Submission No.			033	
Organisation Name or Name of Submitter			Caitriona and Ciaran Byrne (Saint Anthony's, Seatown West, Swords, Co. Dublin)	
Item No.	Section Ref.	Page No.	Observation Statement	TII Response
Letter Re: NA29N.314724 - Estuary through Swords, Dublin Airport, Ballymun, Glasnevin and City Centre to Charlemont, Co. Dublin (MetroLink)				
1	Preamble	1	Open space and design (anti-social behaviour) We support in general the concept of the metro scheme, the objectives of the overall scheme and appreciate that the scheme will bring benefits to the wider city and the environment.	TII are grateful for you taking the time to make this submission and confirming your support for the MetroLink project which will deliver the benefits you have noted.
2	Preamble	1	Notwithstanding this, we have concerns regarding elements of the proposed scheme, in particular the lack of privacy to our property, anti-social behaviour and the level of baseline information and assessment carried out in relation to noise and vibration.	We have reviewed your concerns and have provided responses below.

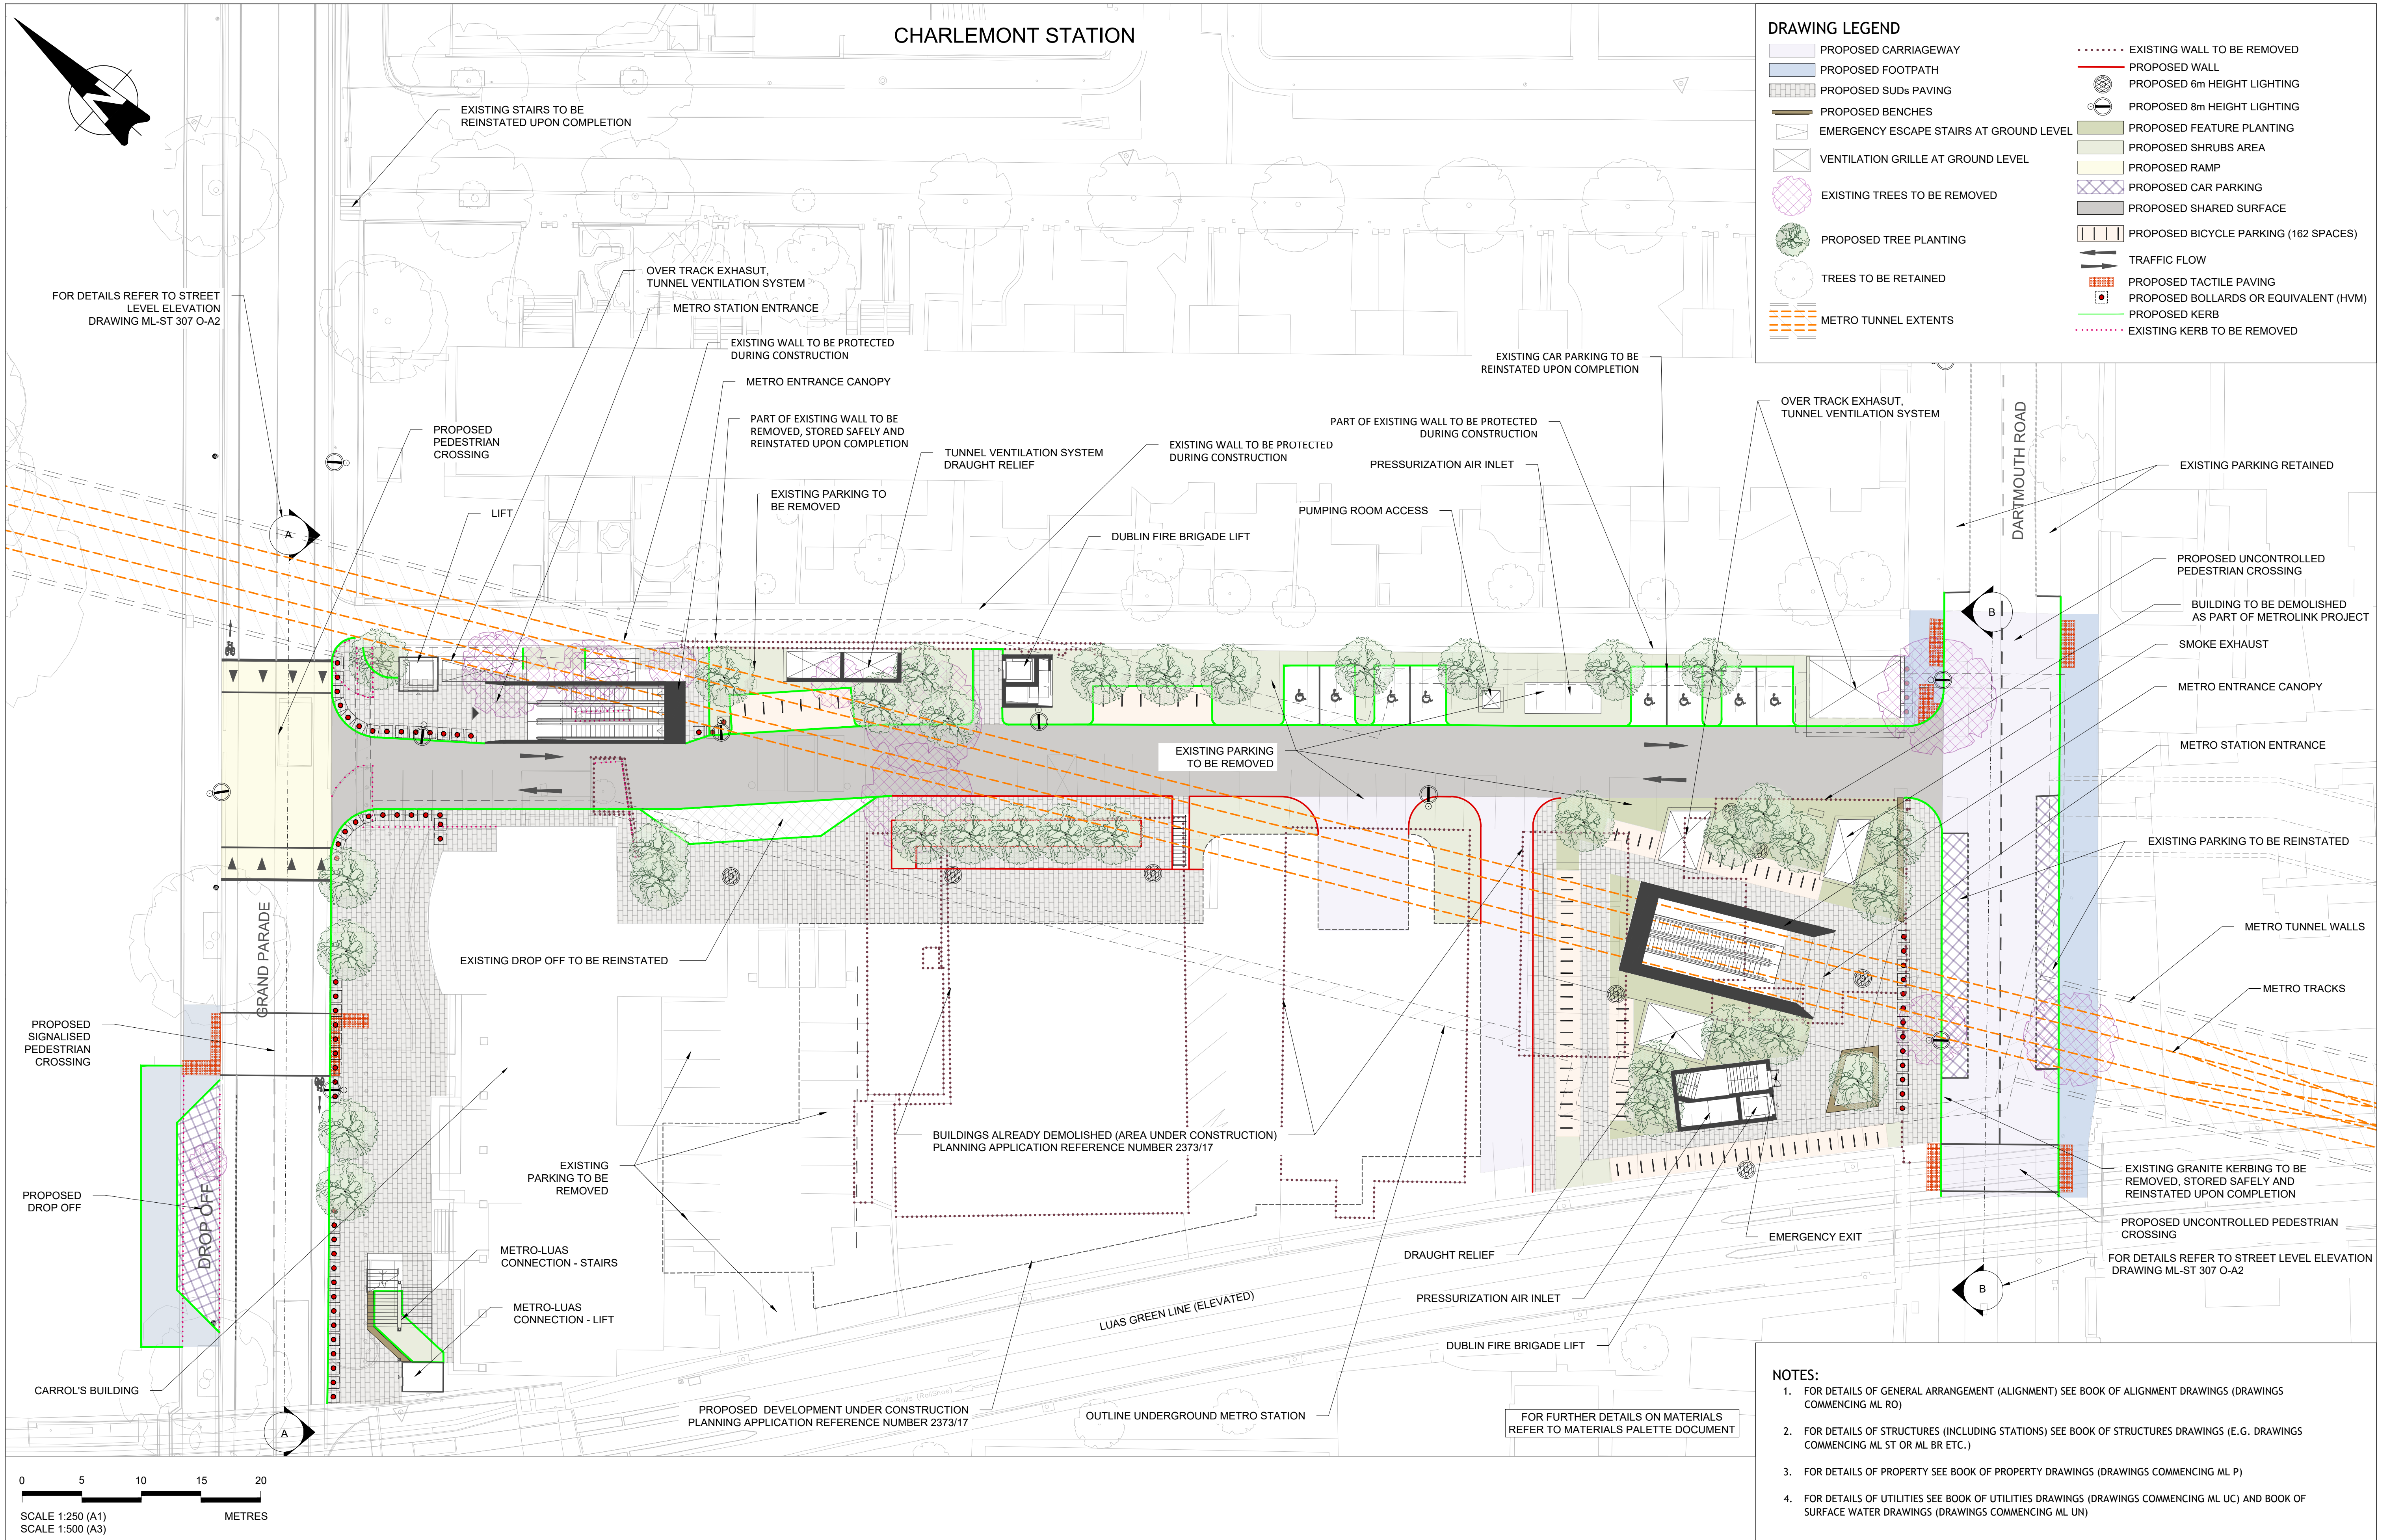
3	1.3, 1.4, 1.5, 1.6, 1.9	2	<p>...the Fingal County Development Plan (the “FCCDP”) which states that ‘Open spaces must be designed to a high specification. Great emphasis must be placed on the quality of open space and details of the proposed landscaping, hard and soft, of these spaces will be required at the planning application stage. Public open spaces should be overlooked and designed in such a way that anti-social behaviour is reduced through passive surveillance [. . .]”.</p> <p>The Open Space proposed ... does not conform to best practice and is contrary to the FCCDP. ...have included mark ups which illustrate: a. The specific Open Space area of concern (area shaded in red, and black dotted line) We are concerned that the current design which has not taken into consideration Best Practice and with the absence of passive surveillance will result in anti-social behaviour. The potential for the proposed Open Space to increase anti-social behaviour and reduce privacy and residential amenity is contrary to the Zoning Objective and Vision set out in the FCCDP for this area.</p>	<p>TII note your concerns, but the design has been developed fully in accordance with best practice and particularly in relation to passive surveillance. The planned outcome of the Metrolink architectural and urban realm design as set out in the EIAR documents supporting the Railway Order has been developed in discussions with Fingal County Council (FCC) to align and compliment the proposed R132 Connectivity Project in accordance with the Fingal County Development Plan. The open space is set to discourage anti-social behaviour, through the attractive setting, use of public lighting, open sightlines, and avoidance of areas where individuals and groups of people can hide. TII intentions in relation to the final landscape proposals around your property are further detailed in response number (4) below. Therefore the proposed Project does not contravene the Open Space designation within the FCCDP.</p> <p>More broadly across the proposed MetroLink, Safety and Security is addressed by EIAR Chapter 6, MetroLink Operations and Maintenance. Section 6.6.5.8 specifically addresses managing the risk of "Vandalism or Anti-Social Behaviour on the Trains or within the Stations", and the wider chapter also addresses the broader design proposals for managing security challenges.</p>

4	1.3, 1.4, 1.5, 1.6, 1.9	2	<p>The Open Space proposed ... does not conform to best practice and is contrary to the FCCDP. ...have included mark ups which illustrate:</p> <p>b. The location and orientation of adjoining properties, which highlight that this Open Space will not be overlooked, and will instead be exposed to gable walls and rear gardens We are concerned that the current design which has not taken into consideration Best Practice and with the absence of passive surveillance will result in anti-social behaviour.</p>	<p>By keeping within the Local Landscape Character Area (LLCA), the proposed MetroLink landscape reinstatement along the R132 between the Estuary and Pinnock Hill Roundabouts provides an integrated series of small local parks complete with play facilities, seating, and planting, adjacent to the residential areas and which interconnects, encouraging pedestrian and cycle use, to form part of the longer green ribbon connecting the broader Swords community with MetroLink and across the R132.</p> <p>The proposed Project has been designed taking into account the R132 Connectivity Project promoted by Fingal County Council. The R132 Connectivity Project received approval by An Bord Pleanála on 20 January 2022 (planning application reference number JP06F.310145). The R132 Connectivity Project aims to improve the connectivity and safety of pedestrians and cyclists moving along, and across, the R132 and enhance facilities for all road users with particular benefits for those choosing sustainable modes of transportation such as bus users, cyclists and pedestrians. The planned outcome of the Metrolink architectural and urban realm design for this linear park is to discourage anti-social behaviour, through the attractive setting, use of public lighting, open sightlines, and avoidance of areas where individuals and groups of people can hide.</p> <p>Further acknowledging your concerns, TII is committed to working with local resident’s groups to align with Fingal County Council plans for urban connectivity across the R132 with local residents concerns and hope to reach agreement on these matters ahead of the oral hearing.</p>
